SSDA 14394209 Bungendore High School

I object to SSDA no. 14394209 for Bungendore High School.

Environmental Impact Statement
New High School in Bungendore
SSD - 14394209

Project
New High School in Bungendore
MAJARA STREET,
BUNGENDORE NSW 2621
Drawing Title
DEMOLITION PLAN

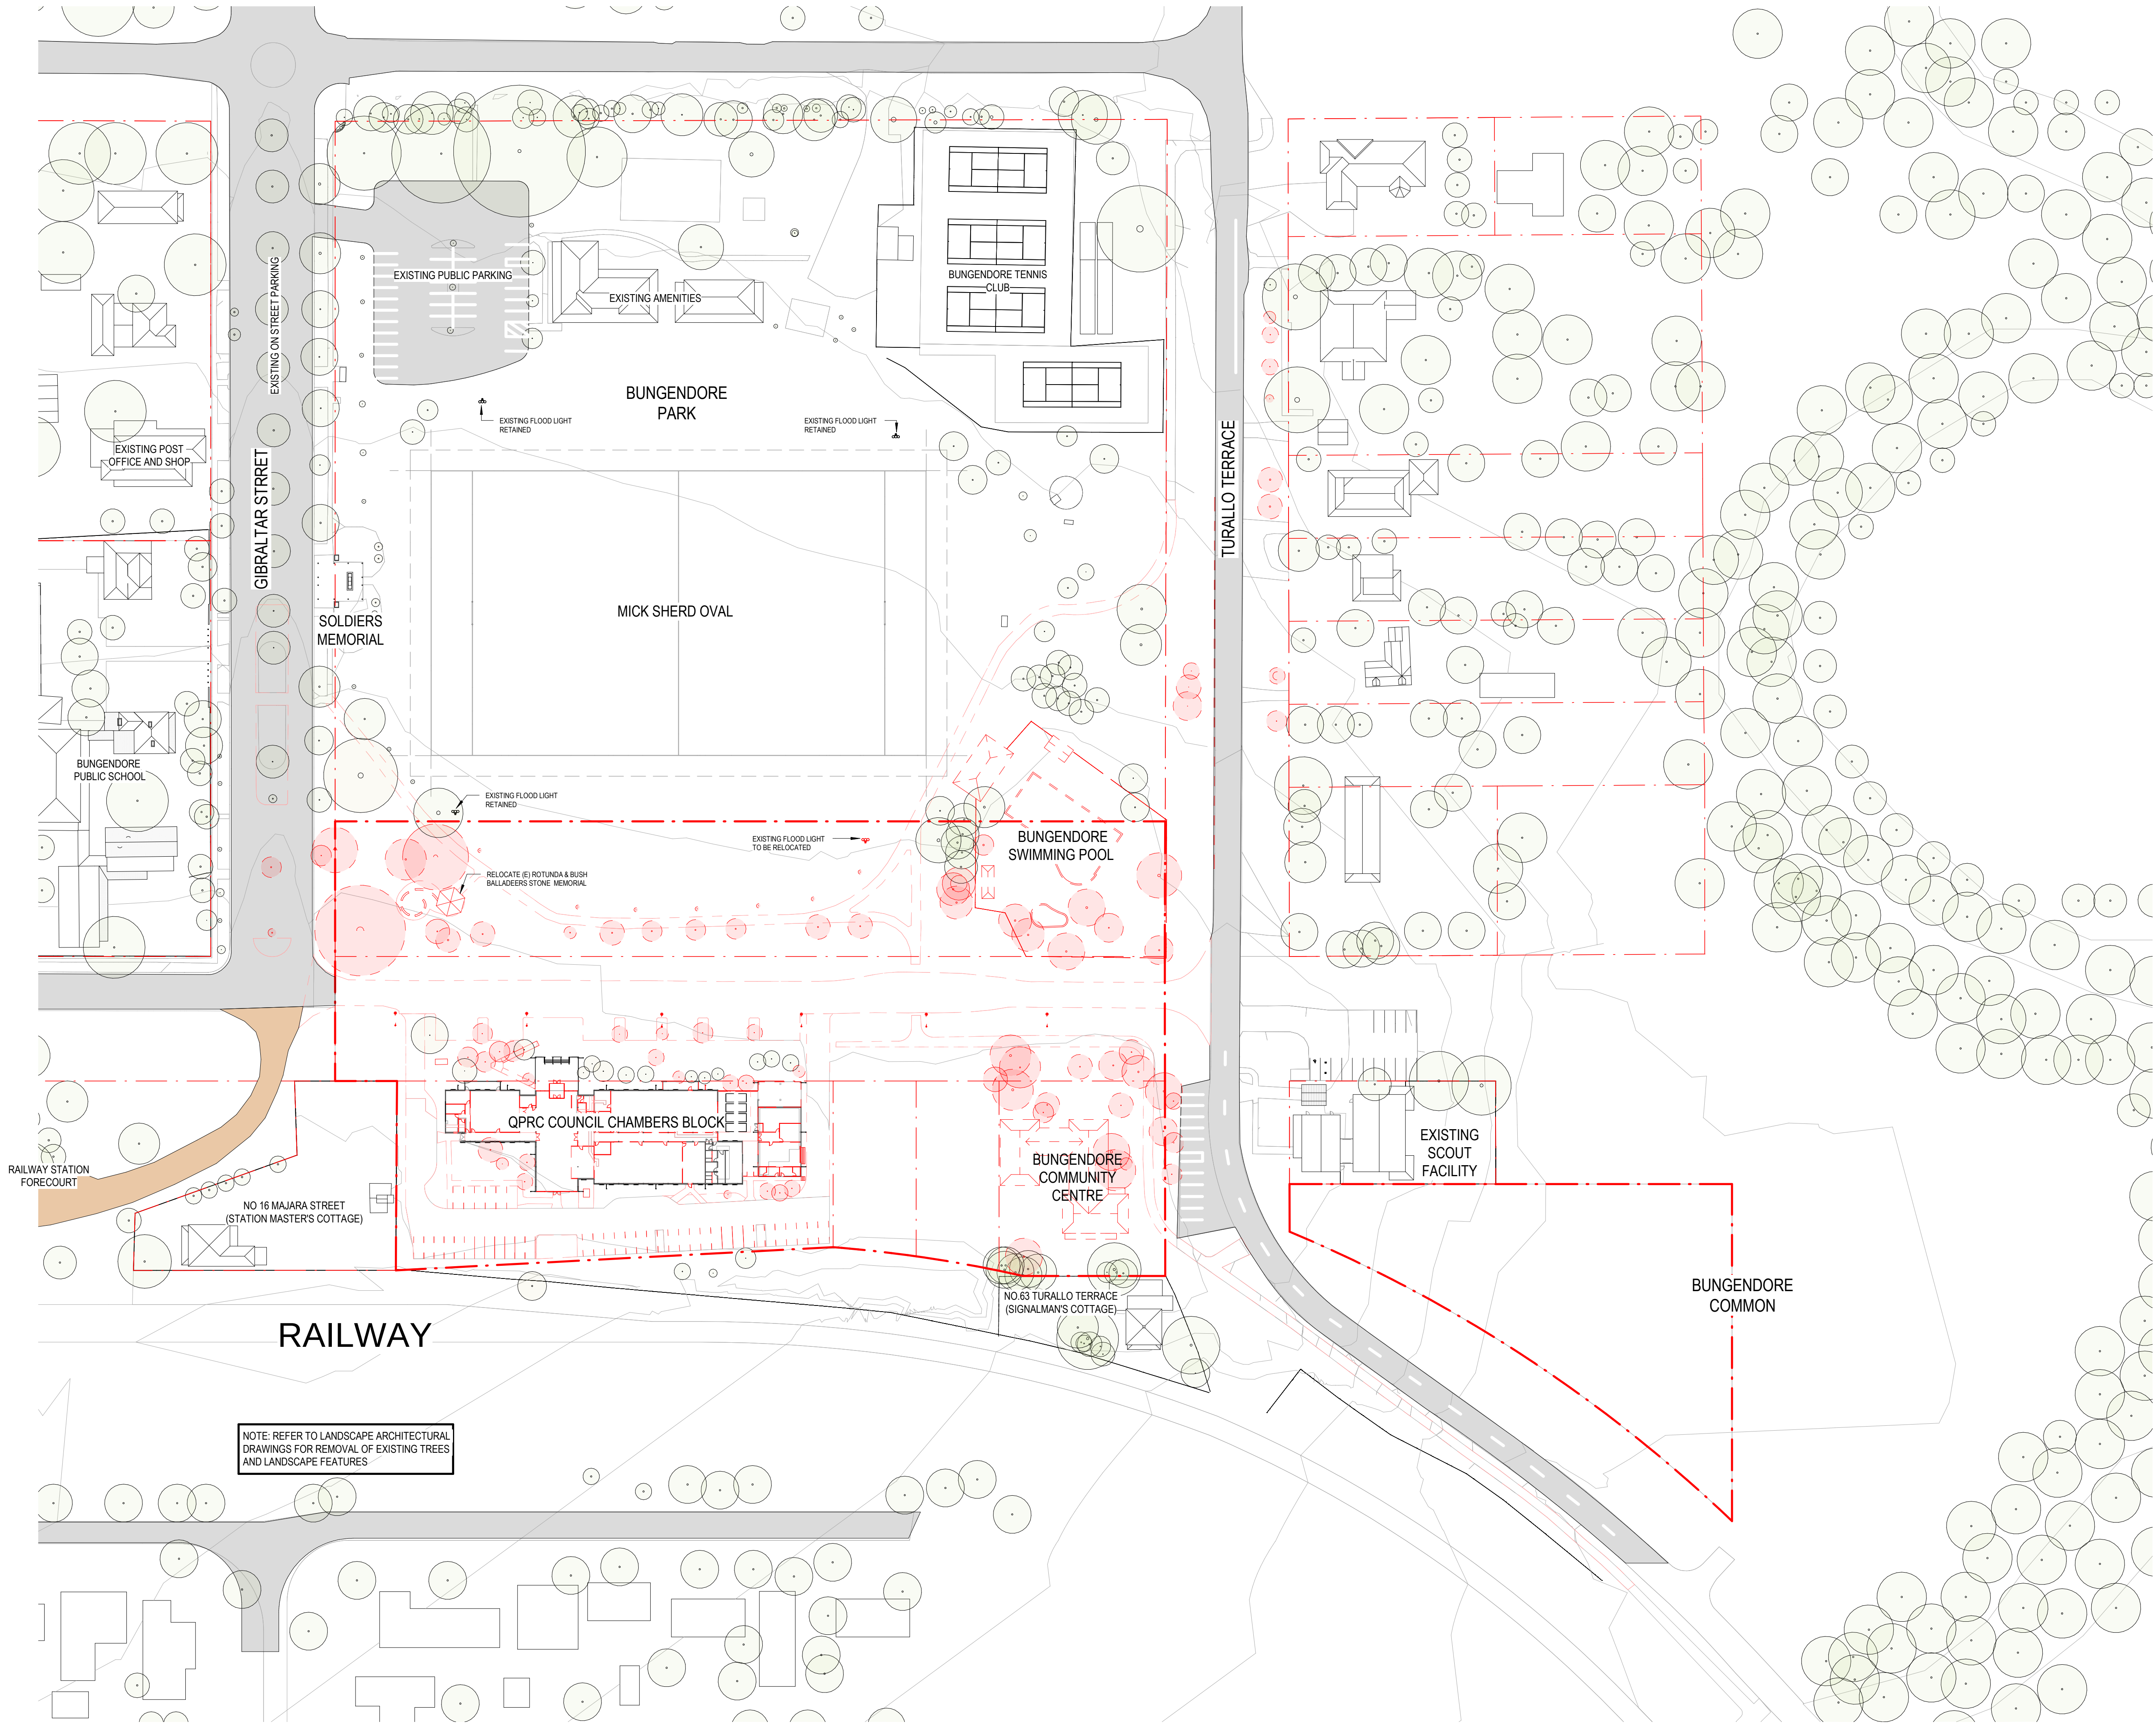
Demolition: I object to proposed demolitions on grounds that a) apart from the road, all the assets belong to the community as much as to QPRC, given they were built partly from community fund-raising and from grants, so their removal is wasteful and disrespectful, b) because knocking down perfectly good and functional buildings/assets in the midst of a climate emergency is irresponsible and ignorant, and c) because no demolition would be necessary if an empty, greenfields site had been chosen.
